Planning Application Ref: A/84/20/T

Location: Tall Trees, High Street, Angmering, BN16 4AW

Description of works: Reduce 2 lower limbs by 2m, reduce 3 higher branches by no more than 1m and remove all pine cones on south east aspect from 1no. Monterey pine tree

T1

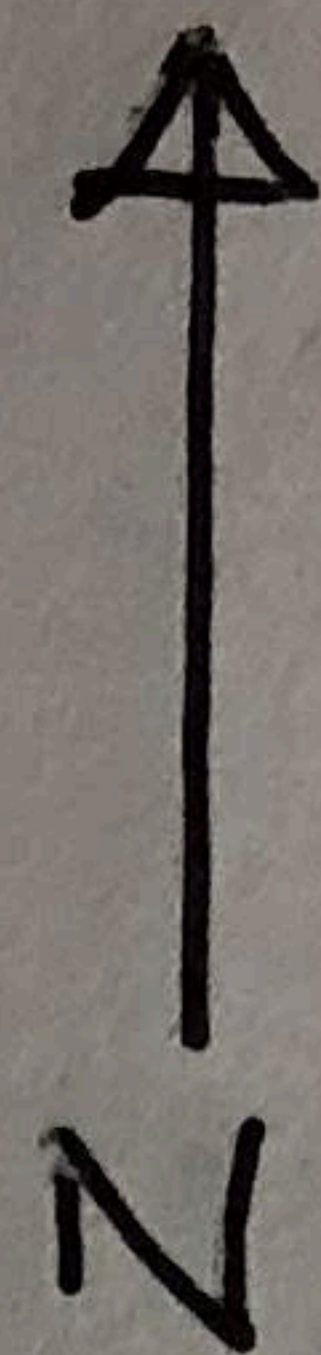
- This tree is discreetly located within the expansive gardens of the owner's property. Although an individual tree, it should be regarded more as an important constituent of a group of 3x Monterey pine that by virtue of size and evergreen foliage has significant presence when viewed from a southern aspect. They are visible from neighbouring properties and the public highway (footway and carriageway) so have amenity value.

- Outwardly and from a distance it appears to be in a fine physiological state and stable although with asymmetric form due to it being dominated by companion tree to the west.

- It is imposing over the applicant's garden, being a large tree of considerable height. The branches of this tree type are often heavily laden with large cones. Those which detach from the tree are usually over-ripe (have discarded their winged seed) and attached to an item of deadwood. As such, they can present a considerable hazard especially when falling from great height.

- The proposal to reduce selected branches and remove cones on a specific aspect to limit the tree's negative influence over garden space has been justified on arboricultural grounds and is consistent with works recently approved by the Local Planning Authority for this tree group over an adjacent plot.
- If the work is undertaken to a high standard, then the tree should be able to remain a long-term visually interesting feature in the local landscape.

- I recommend **CONSENT** for this application, subject to the following condition:

Part a) Where branches are to be shortened back the final cuts are to be made at the correct angle shown in BS3998:2010 and adjacent to a live bud or lateral.

Part b) Cones must be carefully removed from their parent branch or shoot with sharp hand-tools (e.g. secateurs, pruning saw, loppers) only. Needle-bearing branches and shoots must remain intact.
